Please ask for: Nicola Moore  
Email: [nicola.moore@arun.gov.uk](mailto:nicola.moore@arun.gov.uk)  
Telephone: Ext 37944  
Our Ref: AW/49/21/HH  
Your Ref:  
Date: 17th February 2021

**Application for Planning Permission for Works or Extension to a Dwelling**

**Development:** Single storey rear extension  
**Location:** 10 Wyde Feld Bognor Regis West Sussex PO21 3DH

PROPOSED SINGLE STOREY EXTENSION AT 10, WYDE FELD, ALDWICK

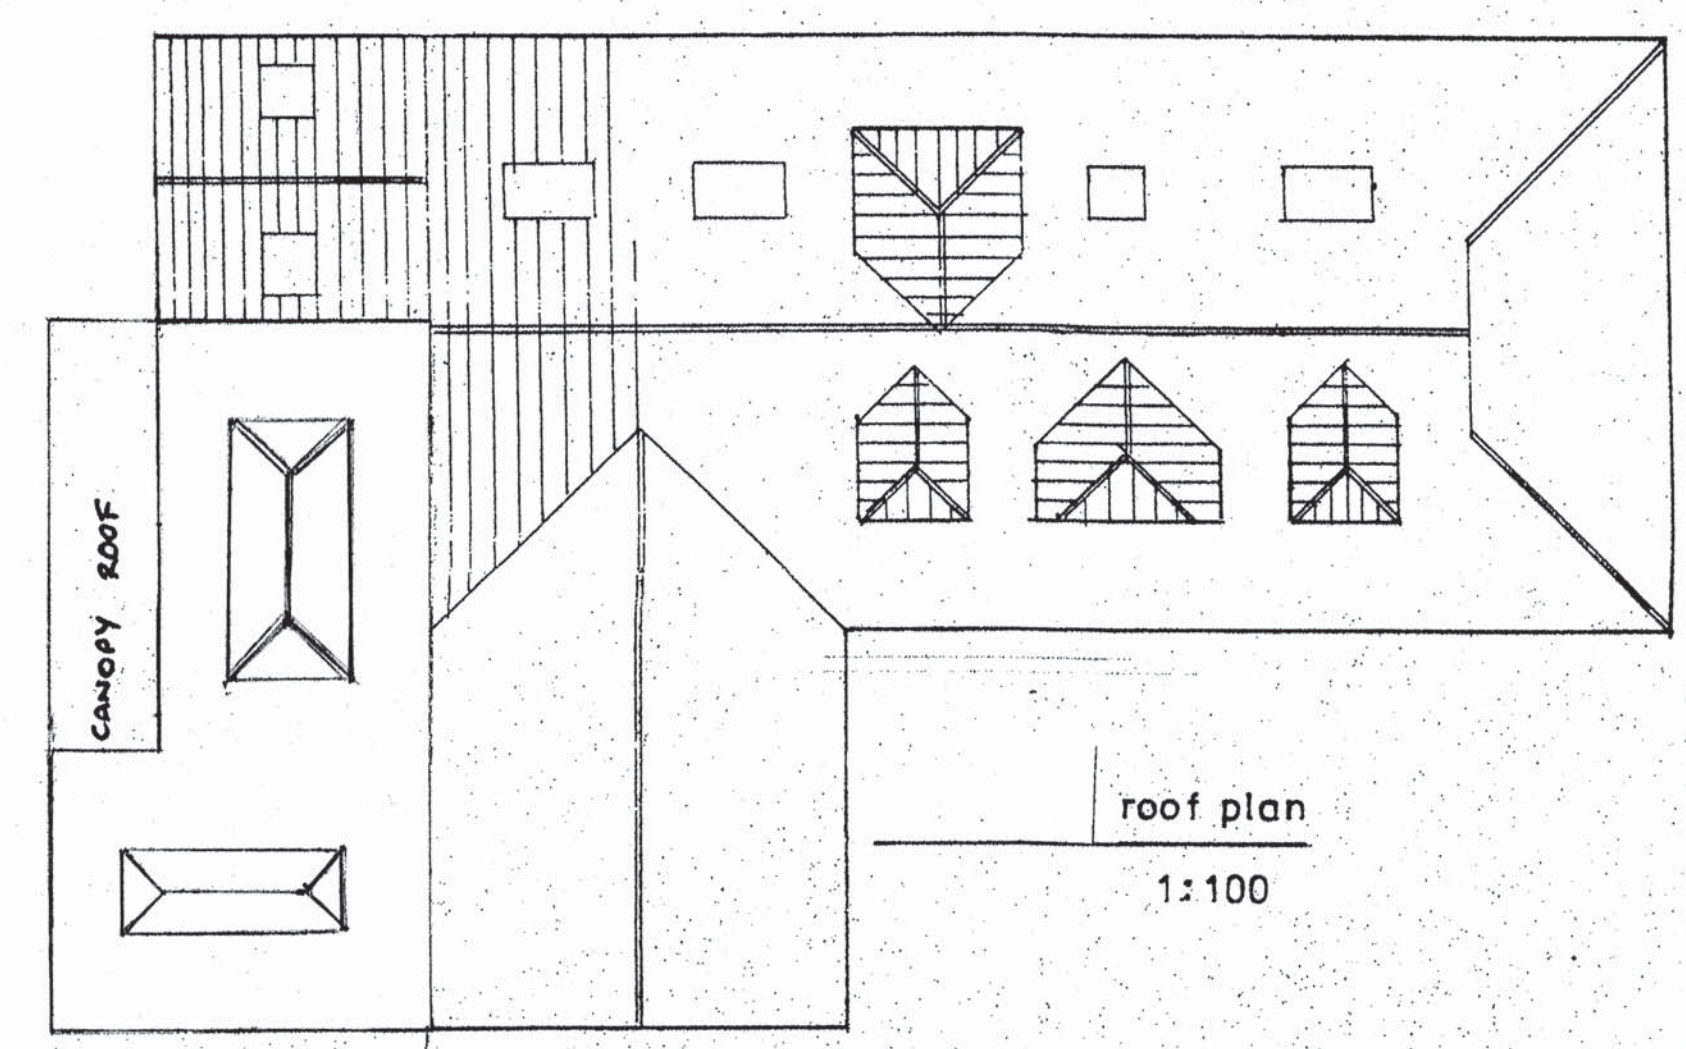
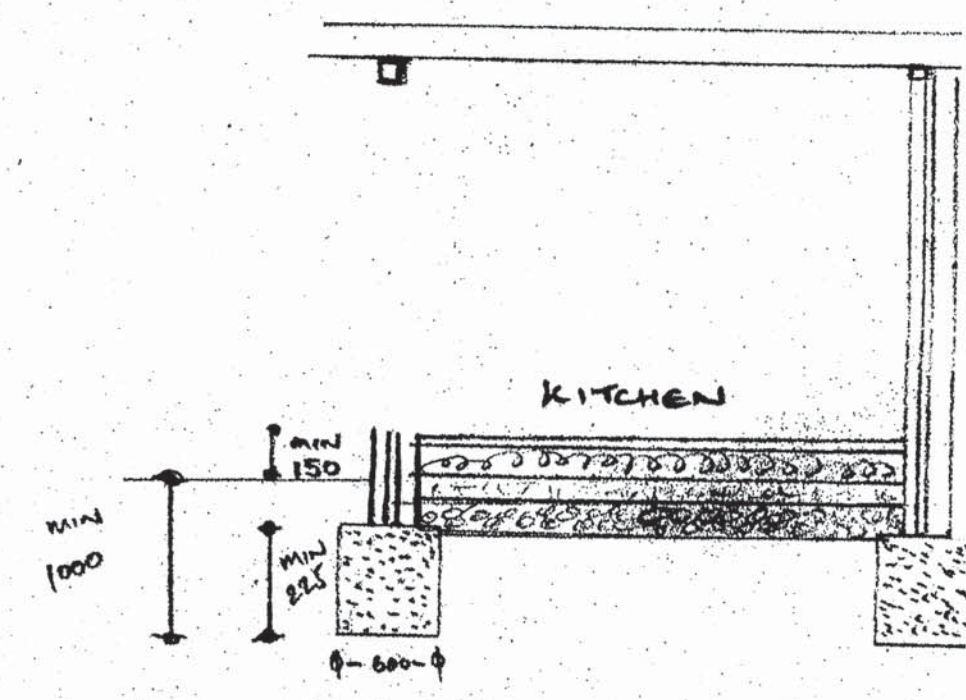
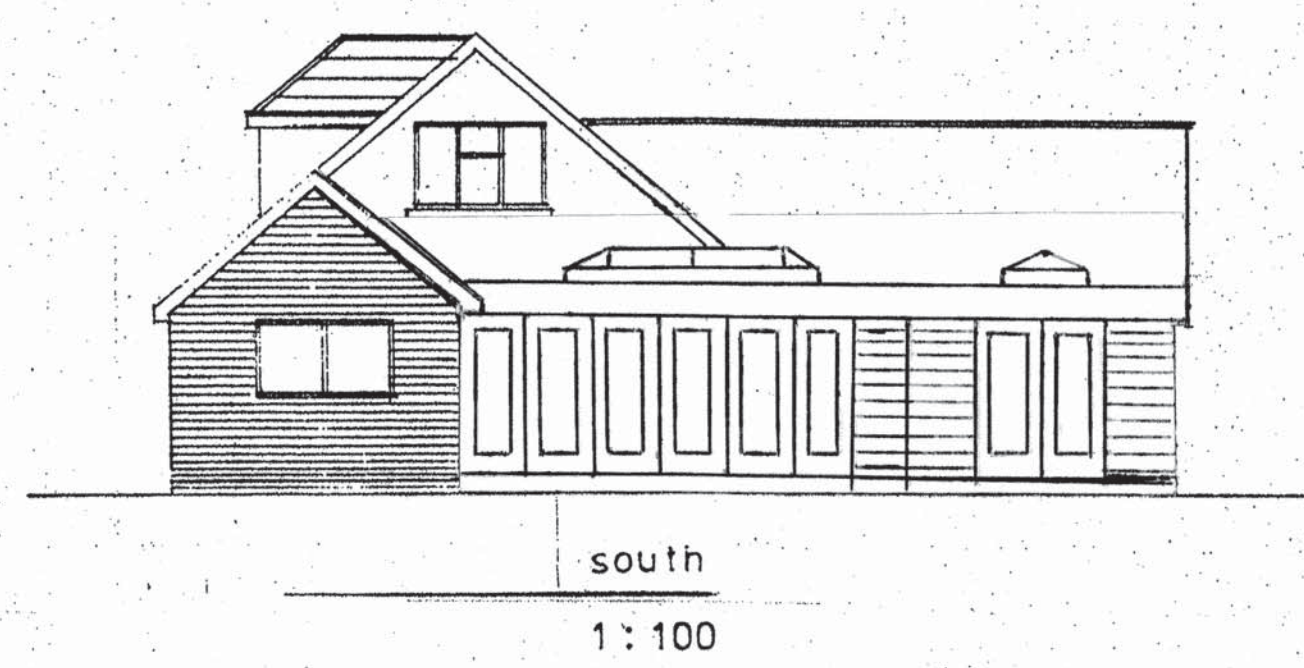
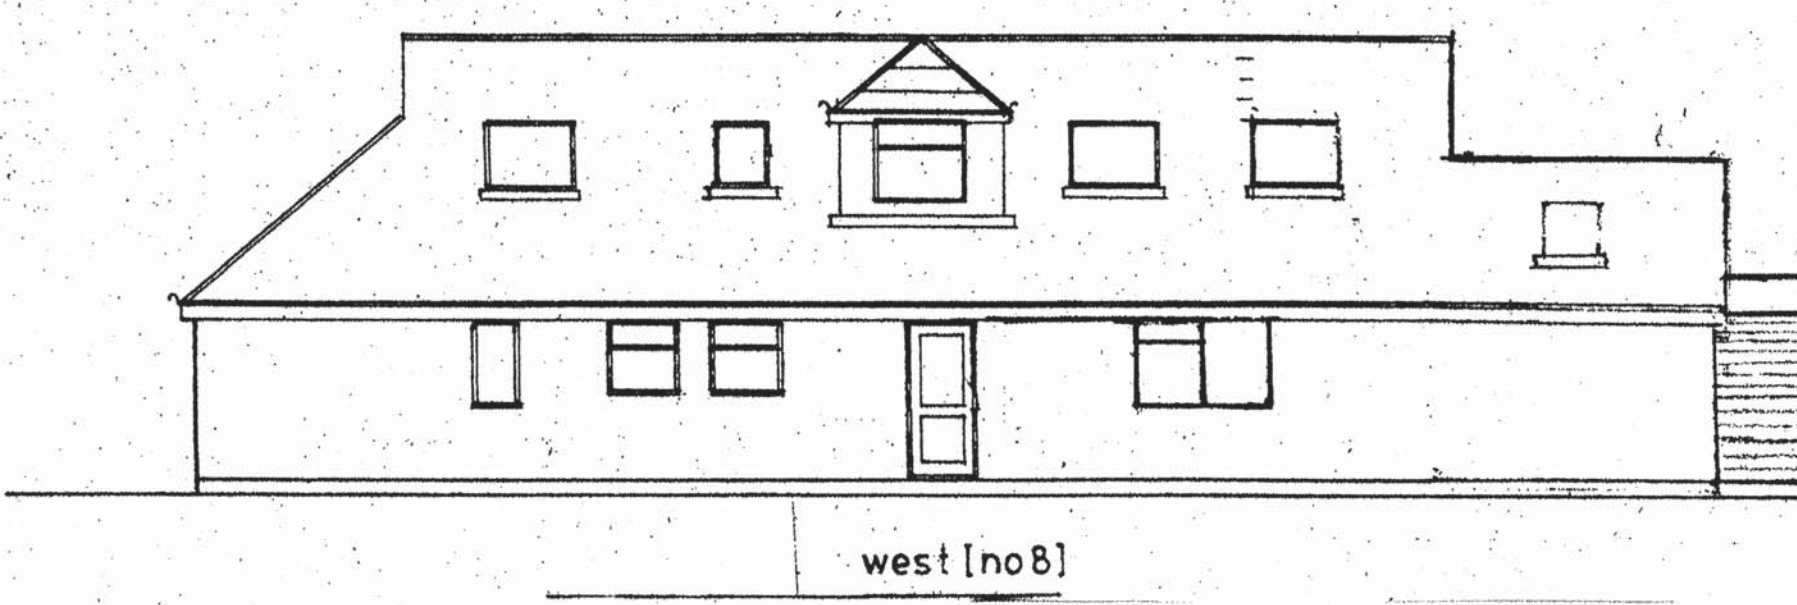
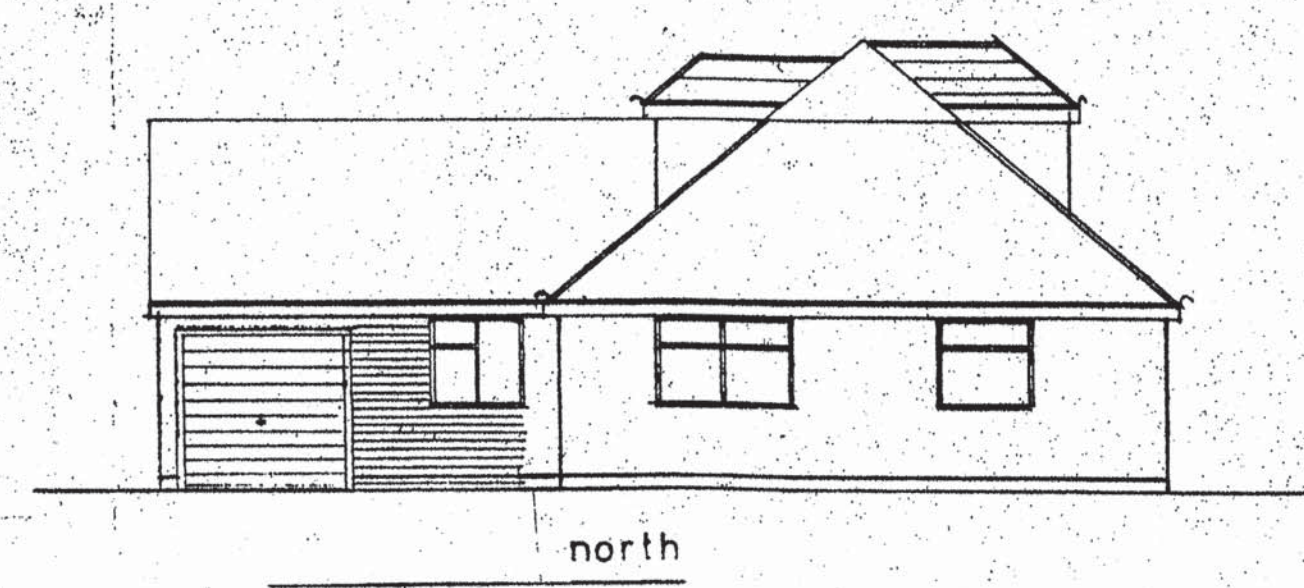
I have checked the measurements on the submitted plans, and there is a discrepancy with the kitchen window. On the Proposed South Elevation it measures 1.8m, but on the Proposed Floor Plan it is 2m. Please check the measurements, amend accordingly and re submit.

location plan
1:1250

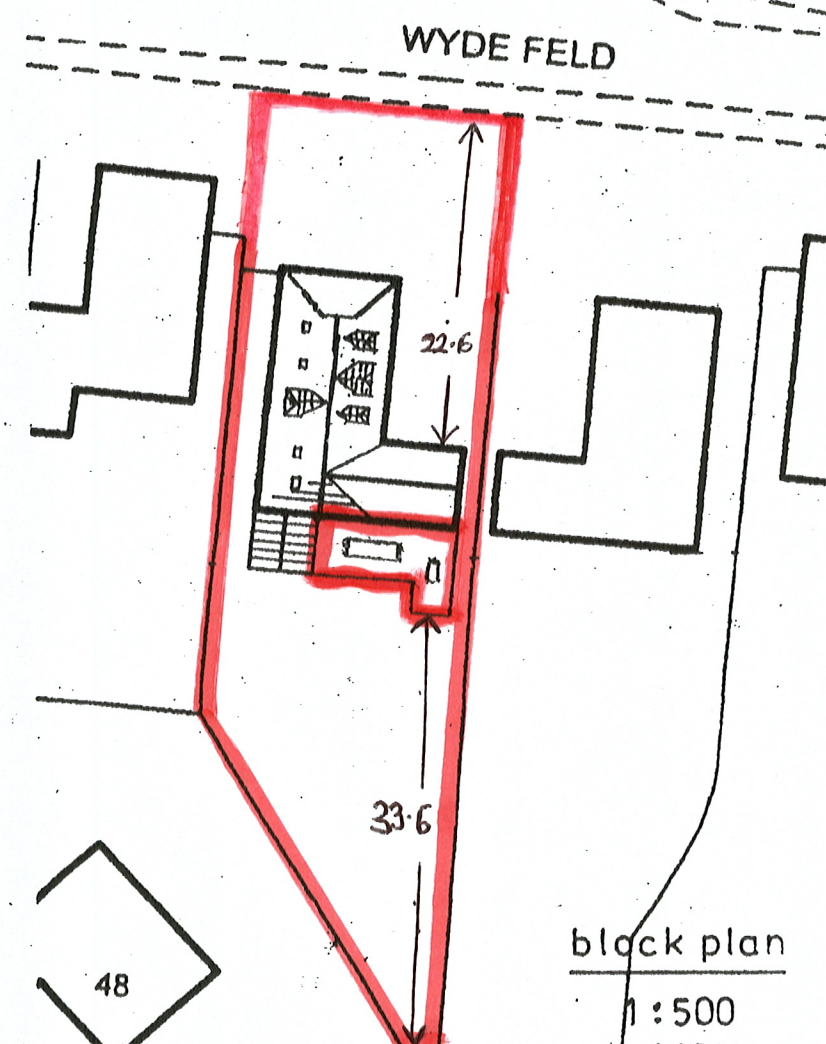
The red edge should include all land, including land required to access the property from a public highway. Please amend accordingly and re submit. Further details of what must be included on the plan can be found in the Validation Requirements List.

block plan
1:500

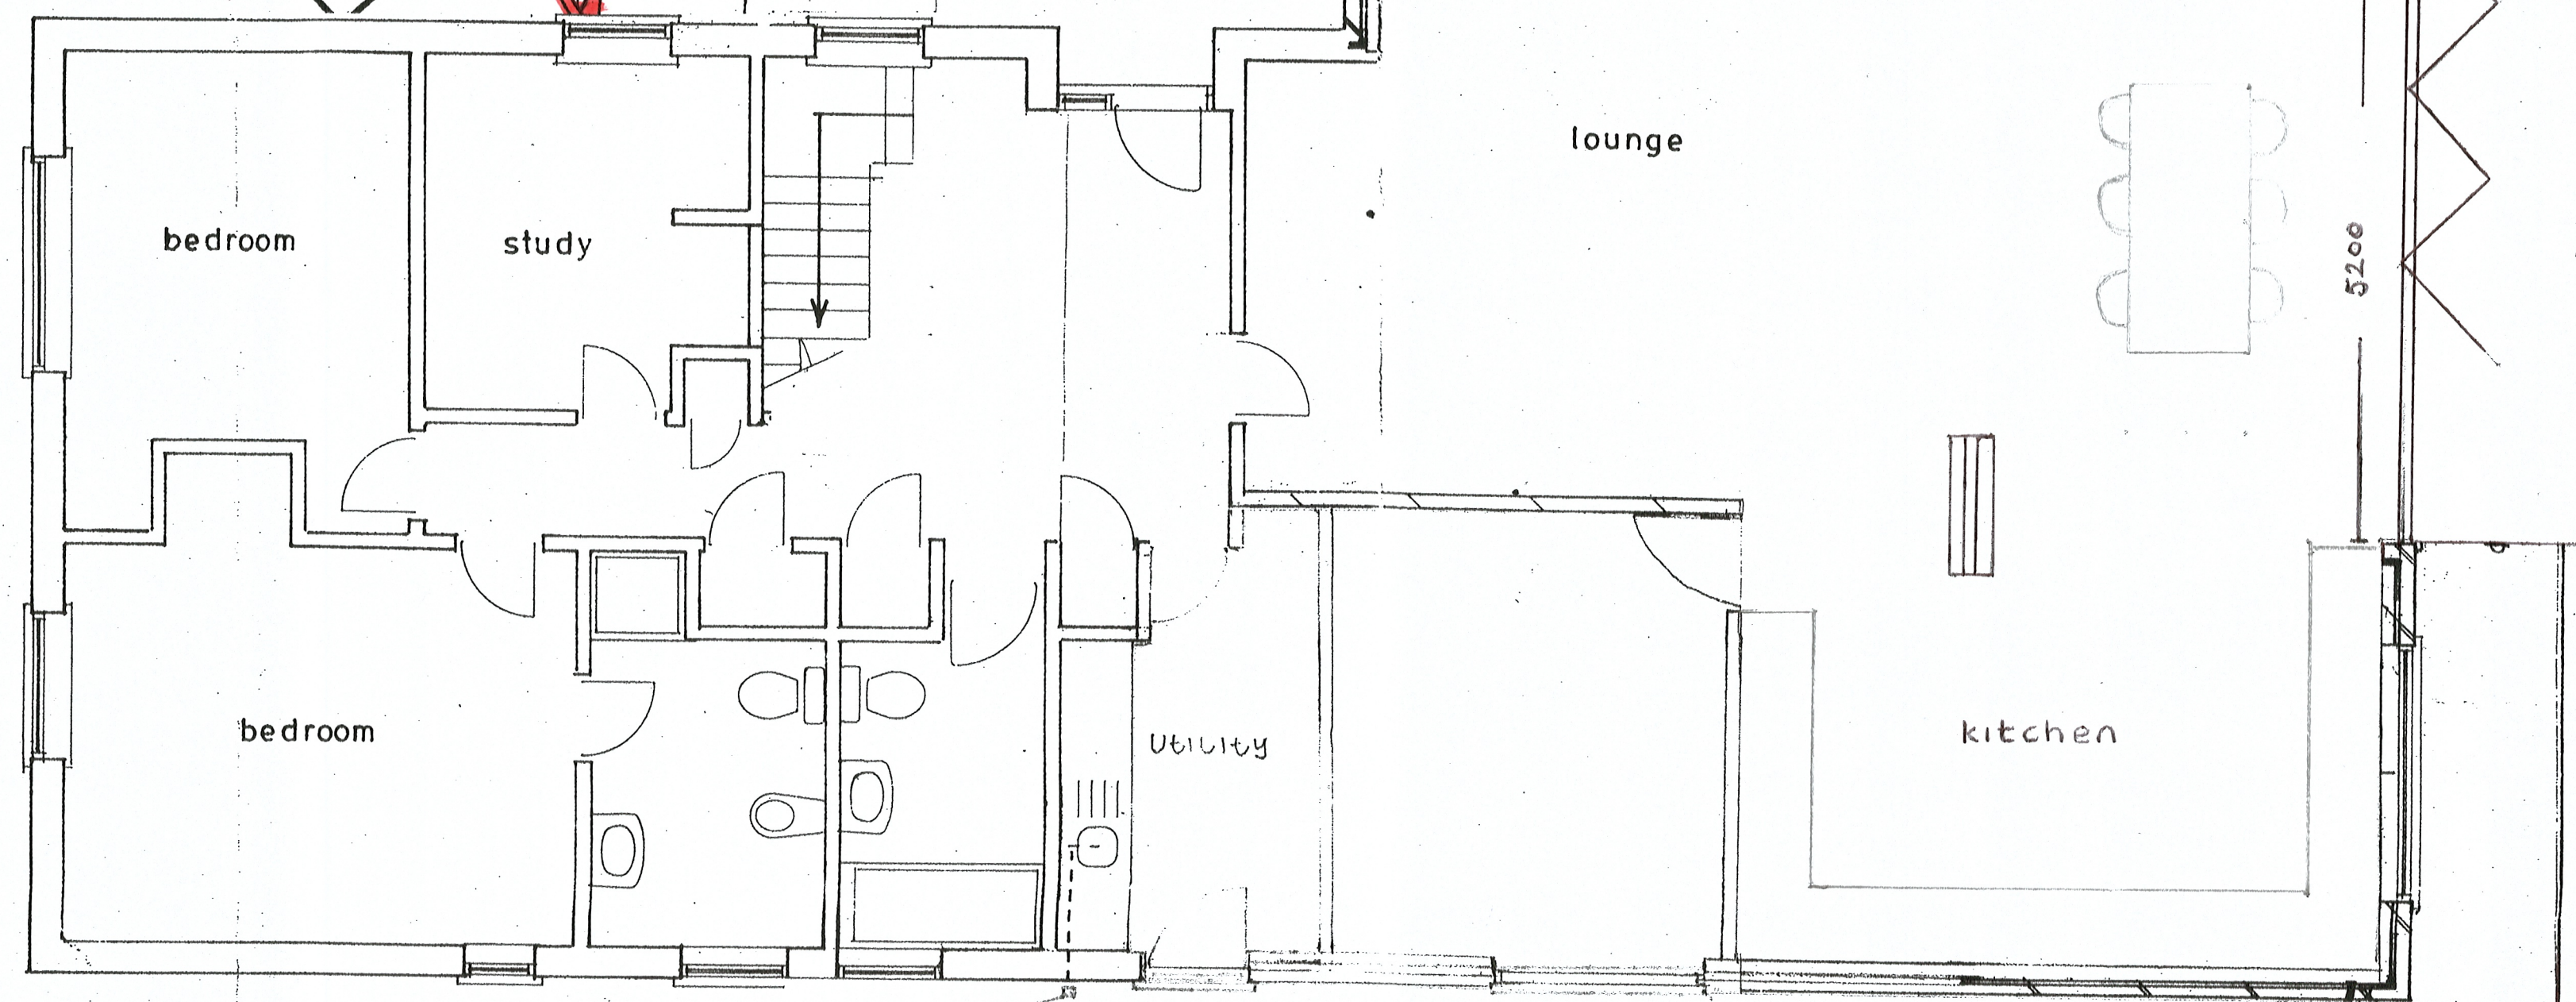
Written dimensions to boundaries are required from the proposed extension. Please amend accordingly and re submit. Further details of what must be included on the plan can be found in the Validation Requirements List.
